Reference: 15.061r05r01

27 July 2022

Re: 23-27 Lytton Street, Wentworthville
Proposed Extension to Wentworthville Northside West Clinic
Supporting Statement

We refer to the subject State Significant Development Application (SSD-17899480) and Council's concerns in relation to aisle turning areas and car park compliance with the relevant Australian Standards (AS2890.1:2004 and AS2890.6:2009). Reference is also made to the latest architectural plans prepared by Team 2 Architects presented in **Attachment 1**.

LOWER GROUND - WEST PARKING

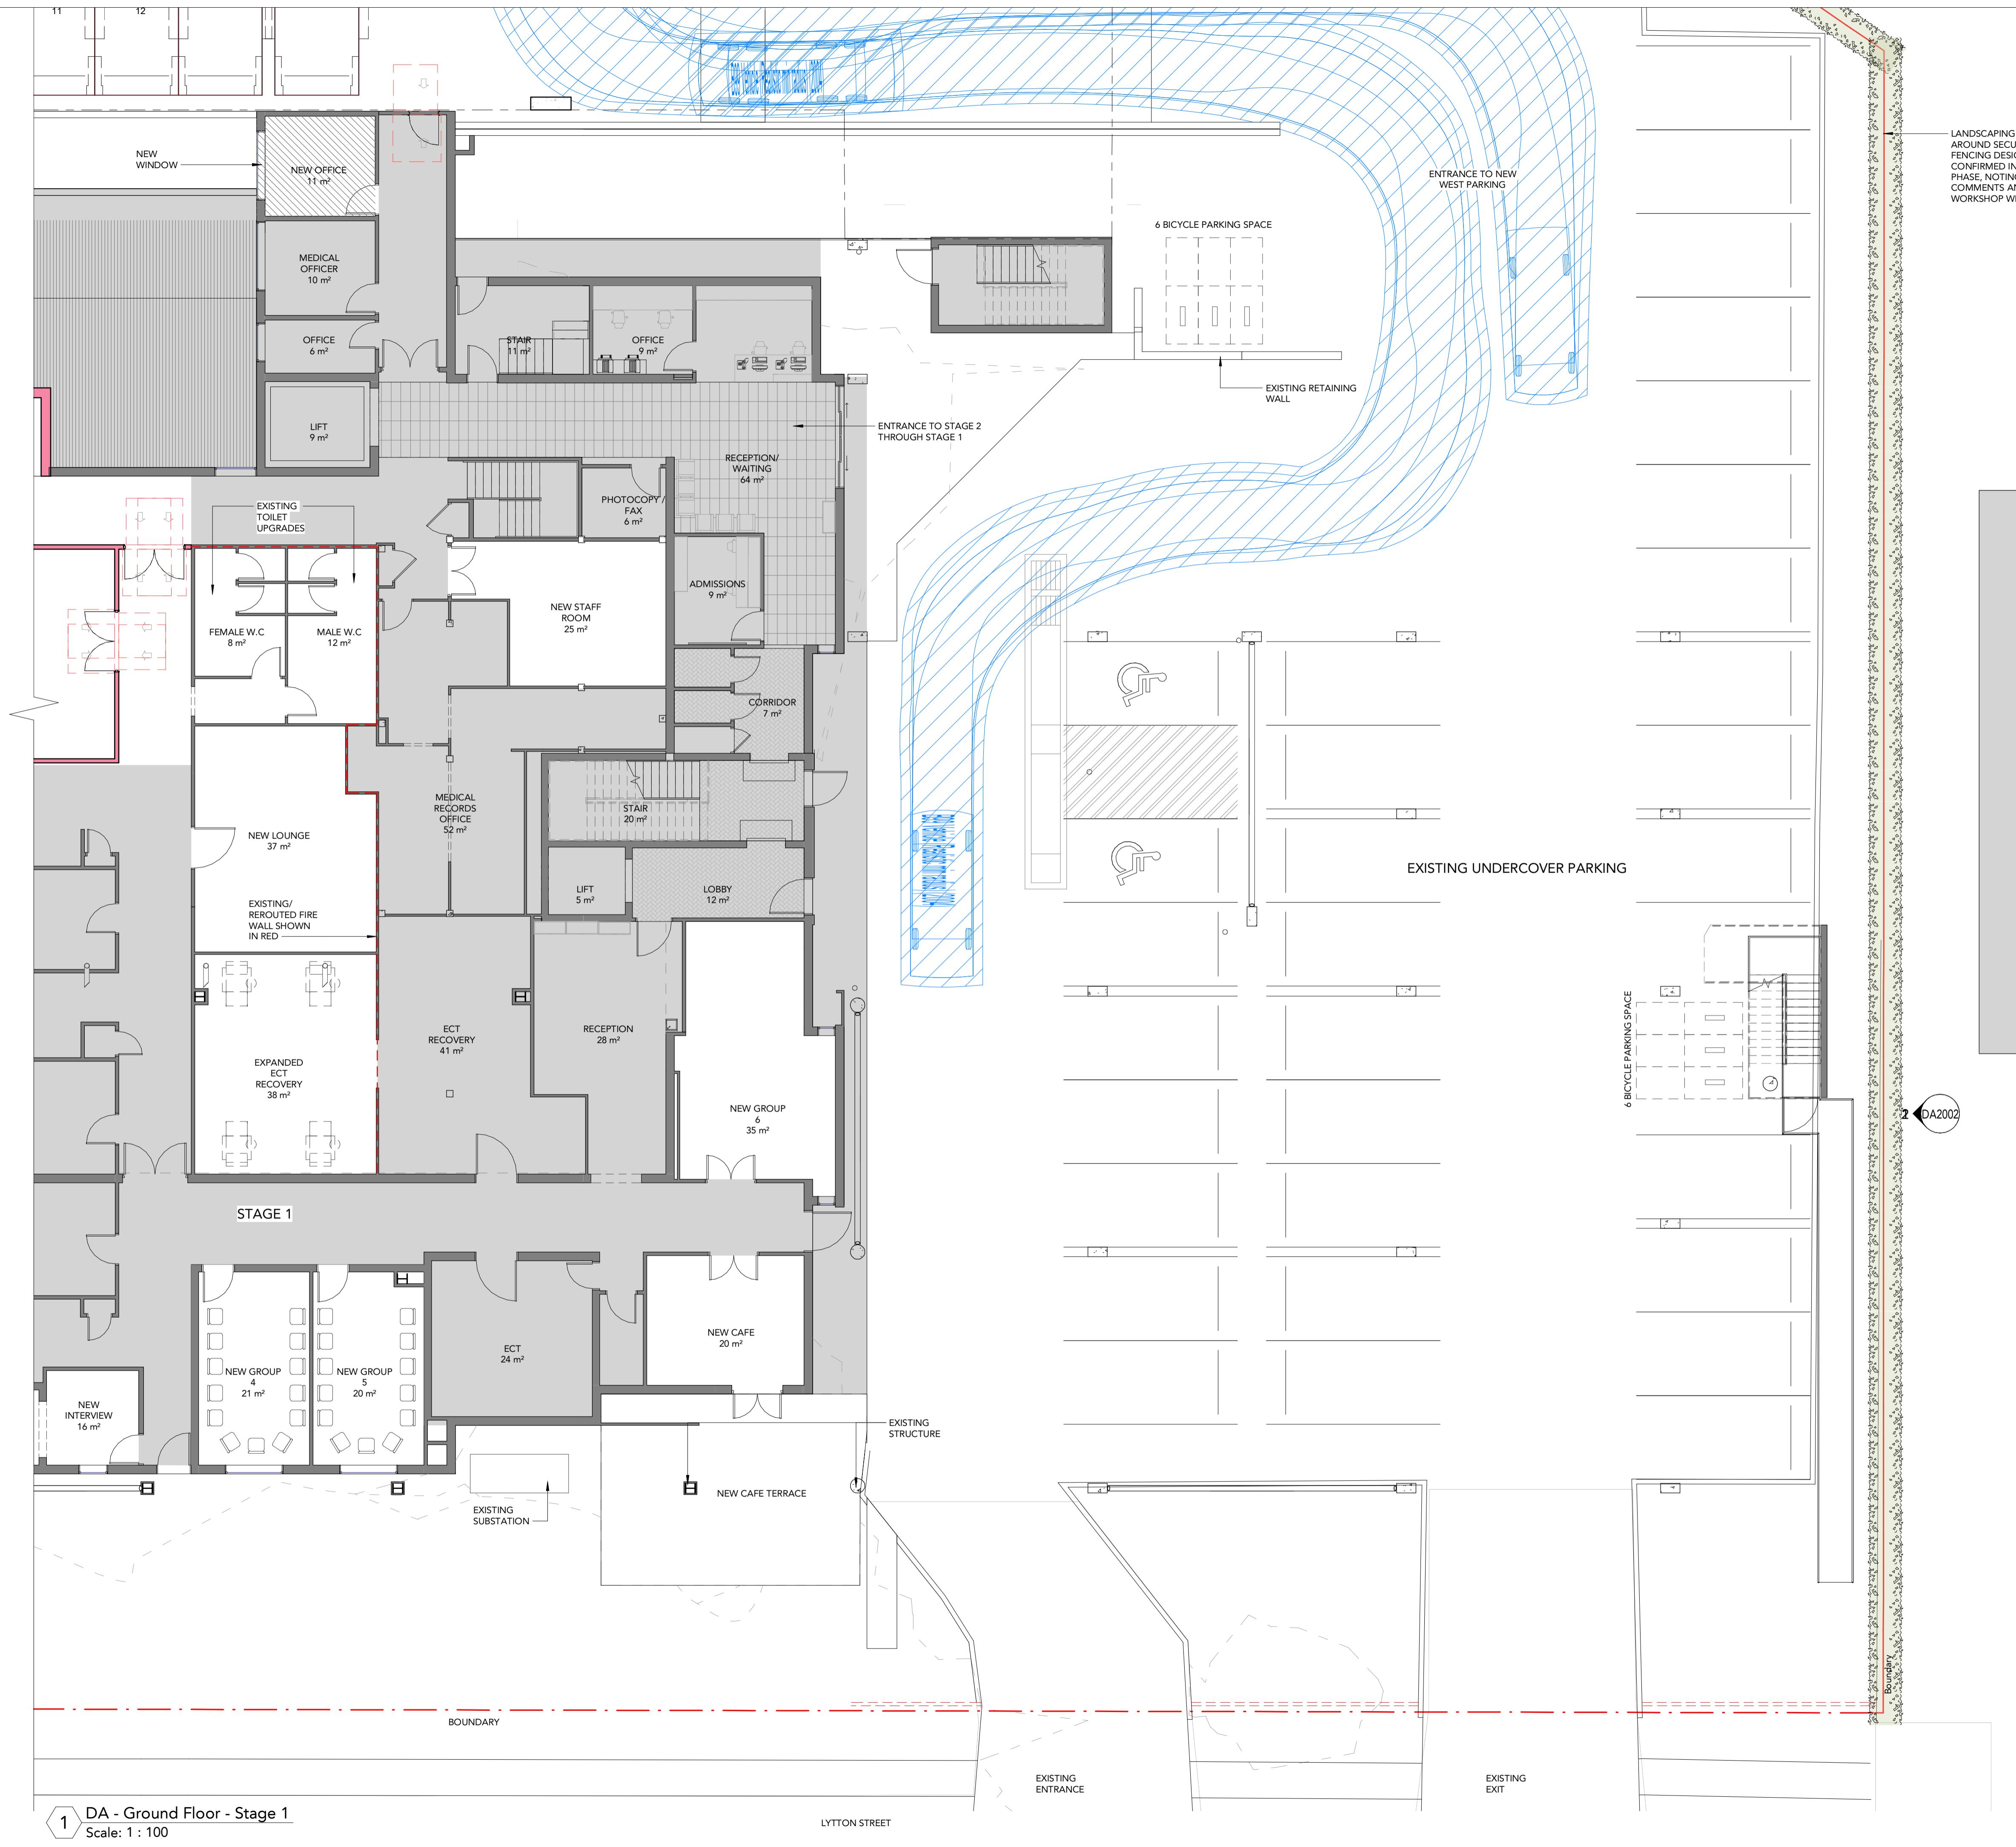
- The new lower ground floor (west car park) is provided with a dedicated vehicle turning bay at the end of the parking aisle.
- The new ground floor (west car park) is provided with a dedicated vehicle turning bay at the end of the parking aisle.

- The new ground floor (undercover on grade car park) does not require a turning bay for the western aisle in accordance with Clause 2.4.2 (c) of AS2890.1 (2004), which states that a dedicated turning bay is only required in car parks open to the public and that the maximum length of a blind aisle is equal to six 90-degree spaces plus 1m. This equates to a maximum length of 16.6m in this instance. The length of the western aisle is only 12.3m and is below the threshold for a dedicated turning bay.

- The new ground floor (undercover on grade car park) does not require a turning bay for the northern aisle, noting that the last three (3) parking spaces will be dedicated 'Staff Only' parking spaces allocated to particular staff. This arrangement ensures the aisle length threshold (16.6m) is not exceeded. In addition, high visibility signage will be positioned over the aisle stating that 'No Visitor Parking Past This Point' to ensure visitors entering this car park can determine if there is any parking available in the first four (4) rows of parking. This arrangement ensures the car park operates in accordance with Clause 2.4.2 (c) of AS2890.1 (2004). If all parking spaces are occupied, visitors can make a 3-point turn at T-Junction of the aisles. This is considered
